Recommendation Report for Planning Permission for Works or Extension to a Dwelling

REF NO: FP/213/19/HH

LOCATION: Greenock Villa
Clyde Road
Felpham
PO22 7AH

PROPOSAL: Formation of new access together with dropped kerb crossover and formation of gravelled hardstanding

PROJECT	Greenock Villa - Crossover	DATE	13/10/17
TITLE	Planning Drawing	DRG NO	IBA/524/01
SCALE	As Noted	REVISIONS

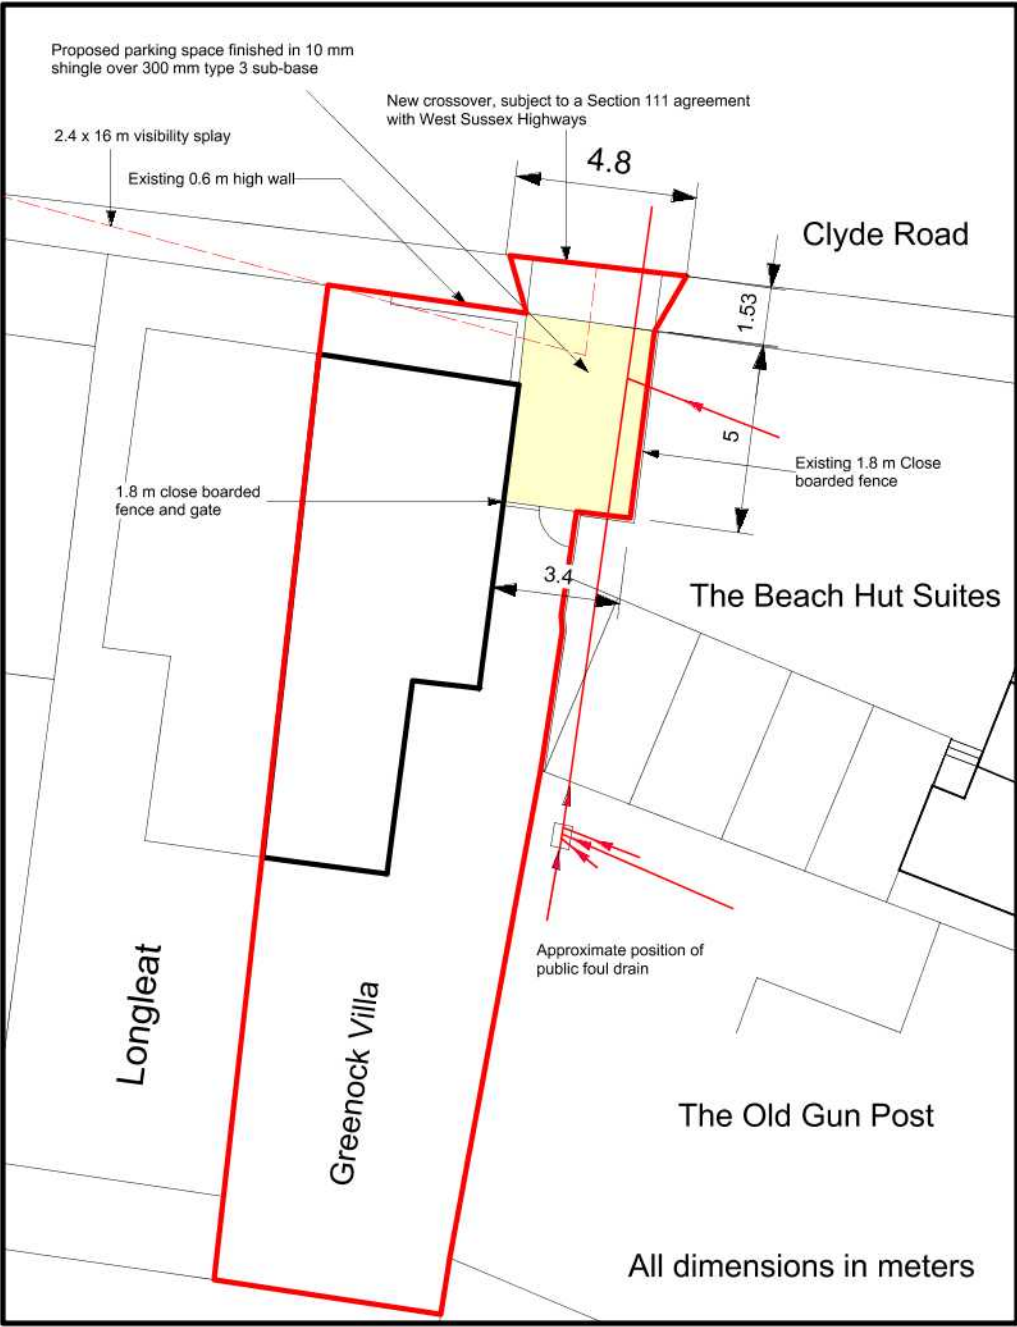
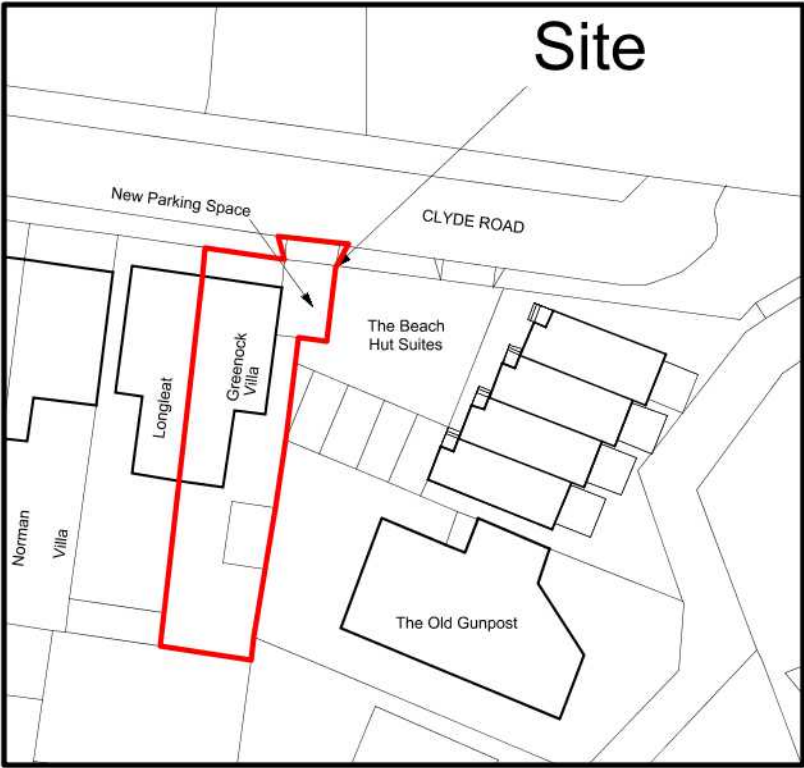
WSCC Highway) - The applicant has failed to supply visibility to the west however due to the properties location in the cul-de-sac, the visibility is acceptable. The proposed drive is to be constructed of gravel. If the LPA is minded to approve, then the LHA ask the applicant to make sure during the design stage that a 'granite set' separates the applicants land from the publicly maintained highway. This should help aid in the applicant keeping the access point free of materials. The LHA does not consider there would be a severe impact. Conditions should be applied.

The proposal will create a new access with a dropped kerb for parking. There are some crossovers evident and the alteration will have little impact on the visual amenity of the locality. The proposal is not considered to result in adverse impacts upon the spatial pattern or character of the area and accord with D DM1 of the Arun Local Plan.

- 3 The use of the parking area shall not commence until the vehicular access serving the development has been constructed in accordance with the approved location/block plan.

- 4 The use of the access shall not commence until such time as the parking area has been constructed in accordance with the approved location/block plan. These spaces shall thereafter be retained at all times for their designated purpose.
